Our Ref: AL/79/21/DOC

Approval of details reserved by condition imposed under ref AL/23/21/HH relating to Condition No 3 - surface water drainage.

Norton Dairy Old Dairy Lane Norton PO20 3AF

Arun District Council have decided to **REFUSE details reserved by condition for the following reasons:**

PROPOSED
FLOOR PLAN & SECTION

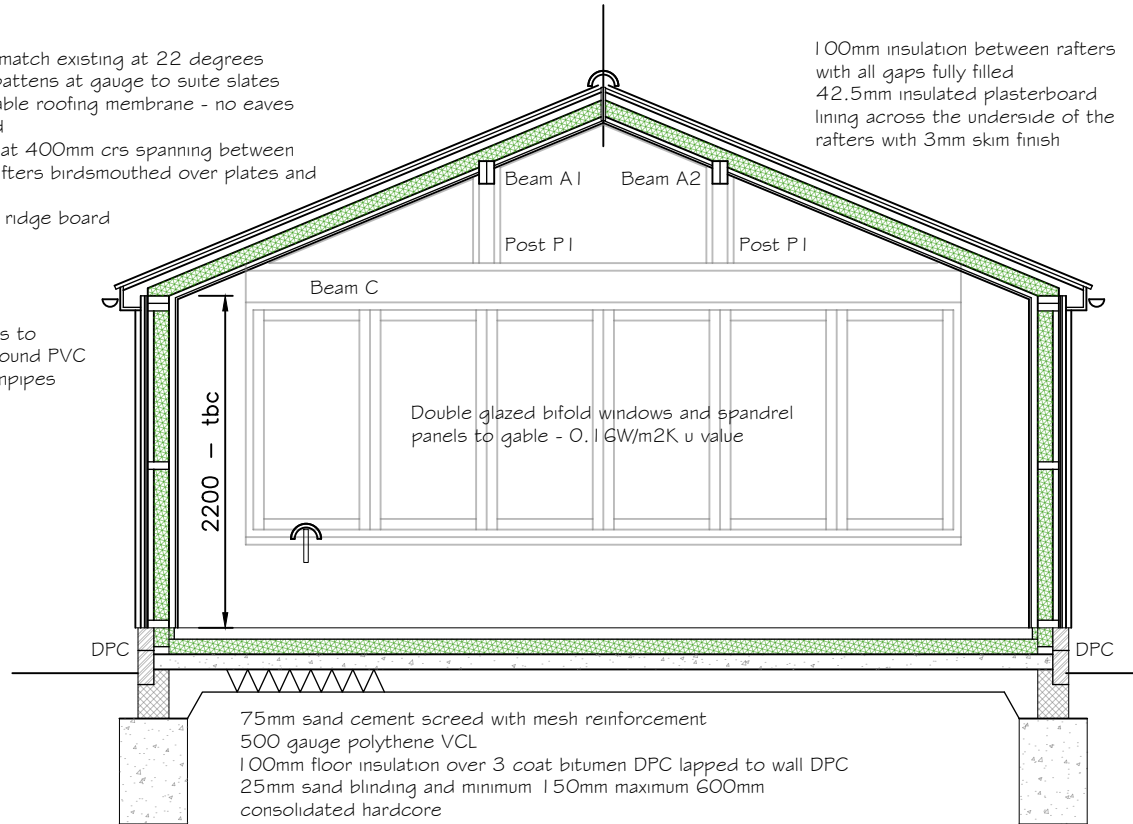
A proposed floor plan has been supplied which shows the approximate drainage layout. More detail on a detailed drainage layout in order to recommend that Condition 3 is discharged. The soakaway shown on the layout appears to be undersized and the calculations to support the sizing are not in accordance with BRE365 or any other approved method.

In order to discharge the condition the applicant will need to supply appropriate calculations to size the soakaway (on the basis of the on-site infiltration rate), a more detailed drainage layout (please see our drainage checklist linked below and pay attention to note 10) plus construction detail drawings (note 11 on same drainage checklist) for all components.
